Submission in response to proposed Pitt Street North Over Station Development (SSD 18_8875)

This Heritage Submission has been prepared in conjunction with a submission by Navon Solutions on behalf of the NSW Masonic Club, 169-173 Castlereagh Street, Sydney, to the Department of Planning and Environment in response to the proposed Pitt Street North Over Station Development (OSD).

The Proposal - Concept State Significant Development Application - The Pitt Street North Metro Station and OSD

Figure 10: North-South Section showing proposed OSD and the NSW Masonic Club in blue

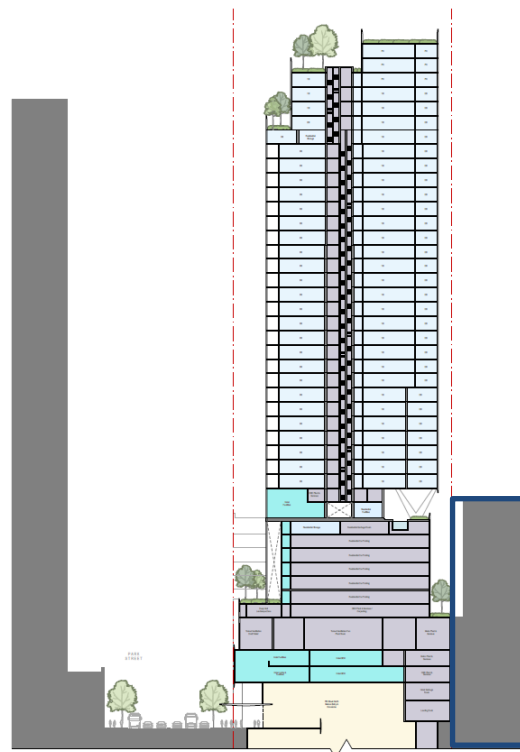
The north south section within the drawing set illustrates the proposed podium from ground level to level 5 as built hard to the Club’s southern boundary. Figure 8 indicates the location where this section occurs. The section does not describe the setback that also occurs along this boundary of the Club due to the indented floor plan.

The *Indicative Scheme Drawings* presented in Appendix F: Urban Design and Built Form of the application presents inaccurate setback information between the proposal and the NSW Masonic Club's southern boundary between ground and level 6. The north south section in the application indicates the Club has a zero setback at these levels. The Club's floor plans show there is an approximate setback of 1.6-2.2m. The proposed podium design should respond to the high significance of the NSW Masonic Club and provide an equal setback, that is a 2.2m setback over these levels to act as a mirror to the setback of the Masonic Club Building.
